From: Simon Davis
Sent: 19 July 2018 11:16
To: Karen Parsons
Subject: FW: AL/136/17 - Land West of, Fontwell Avenue, Eastergate, PO20 3RU

Please see final response from Highways raising no objection subject to conditions. They just require one final small change to the red edge as per the below paragraph:

PROPOSED SITE PLAN 1:500

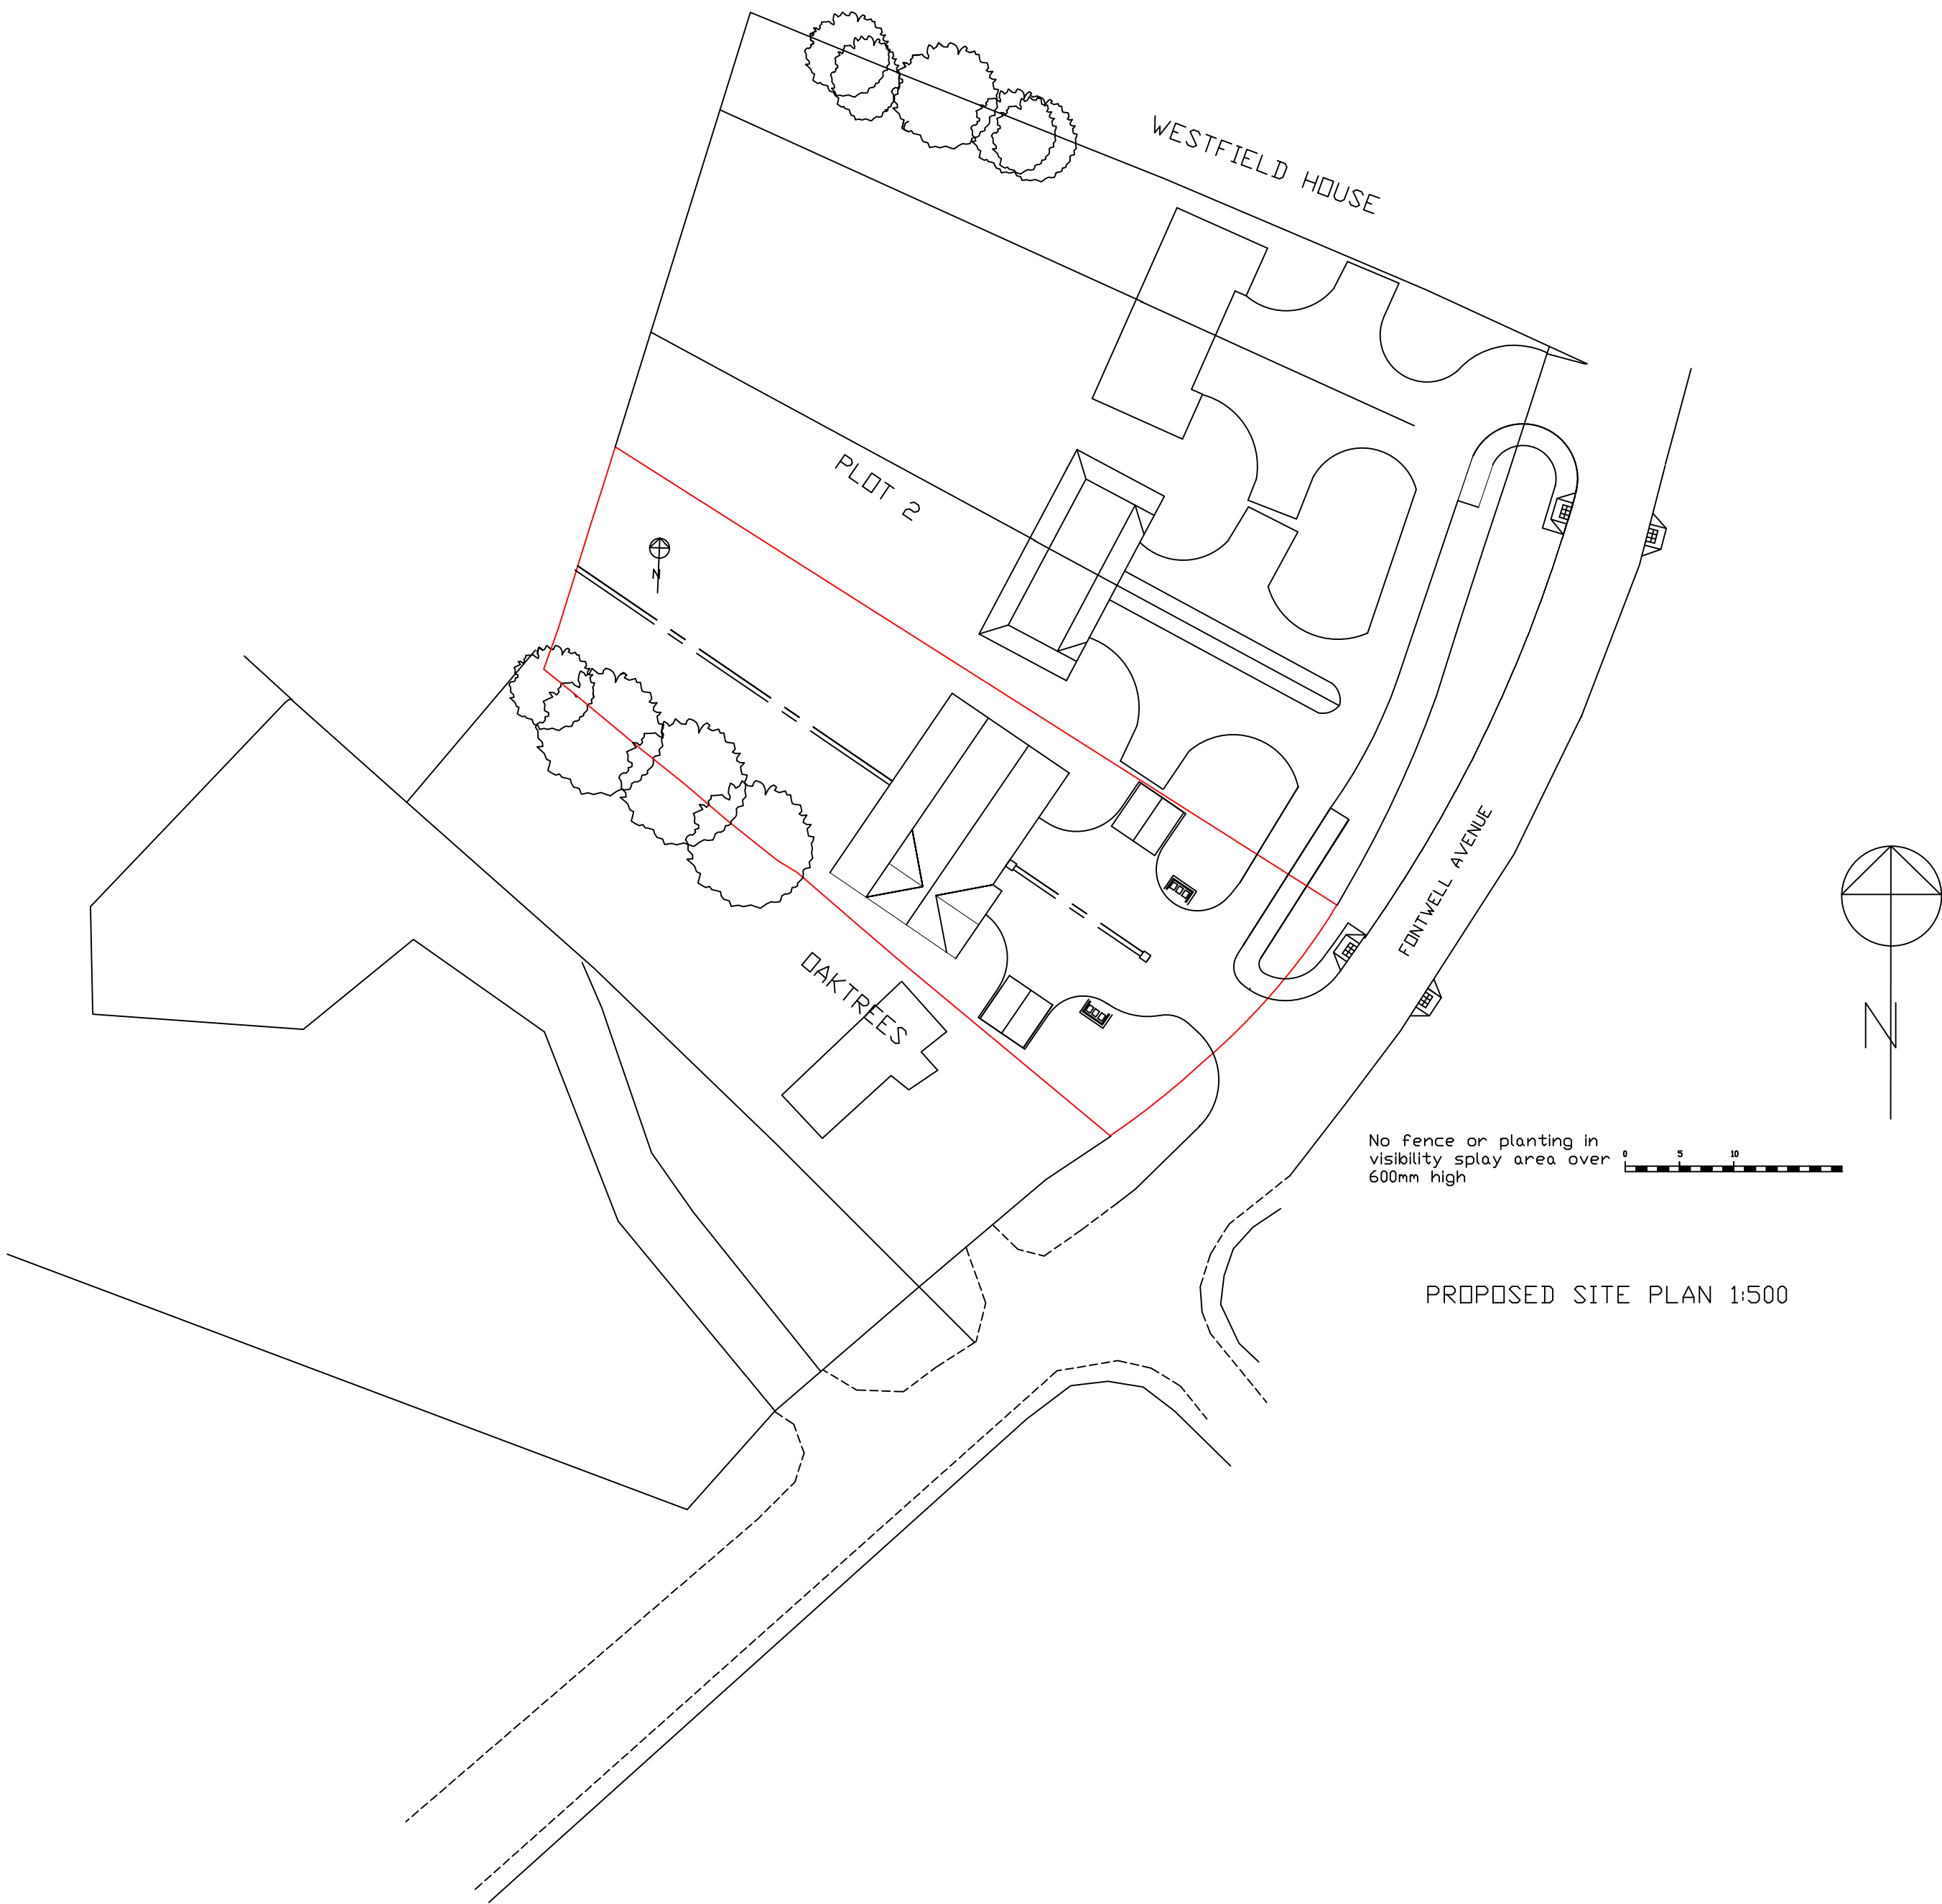
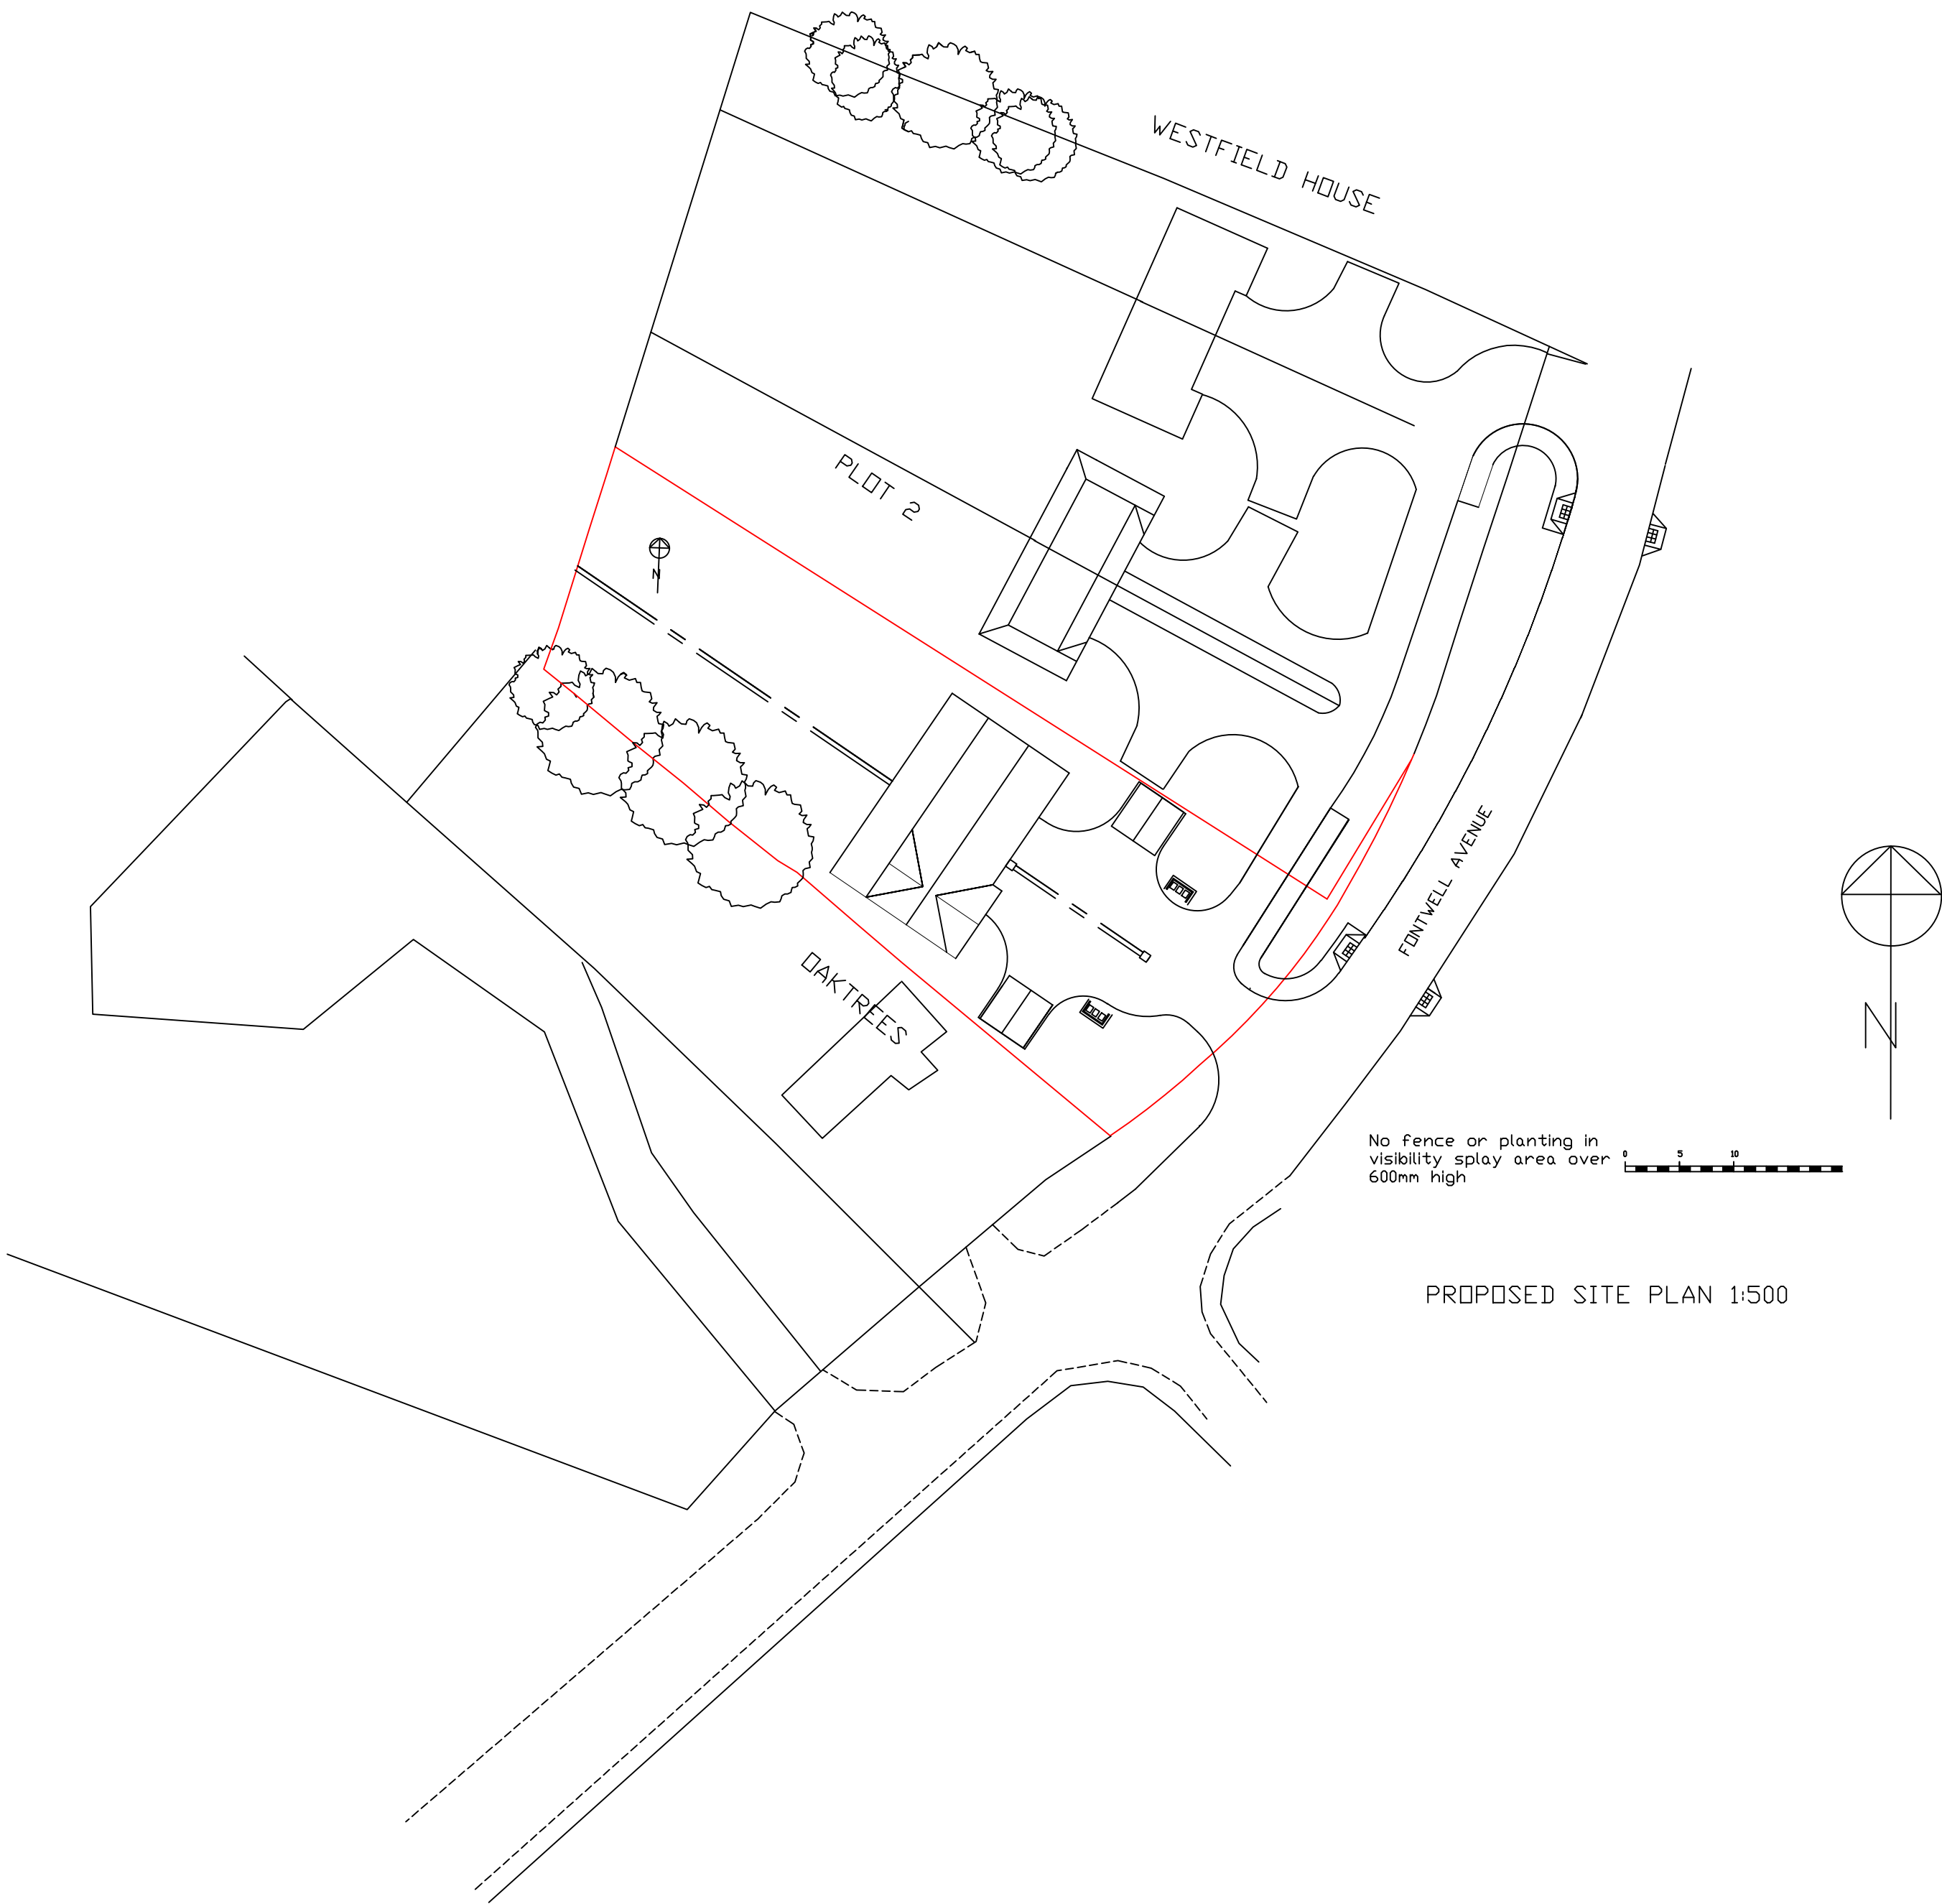
"Using the latest submitted plan it is however possible to plot a 2.4 x 59 metre splay, however there would be a requirement to use land outside the red edge to provide such a splay. This land is etched in blue on plan 2018-4370-001 and therefore it is not unreasonable that the applicant could secure this land to provide adequate visibility splays by way of planning condition. The Local Planning Authority is advised that this would require an amendment the red edge plans submitted."

Can you provide new plans to reflect this change. We do not consider it necessary to re-consult the Parish Council or Neighbours on this change. However, I will need an Extension of Time until the 7th September as this will not now be able to go to the August Committee. The next committee is the 5th September.
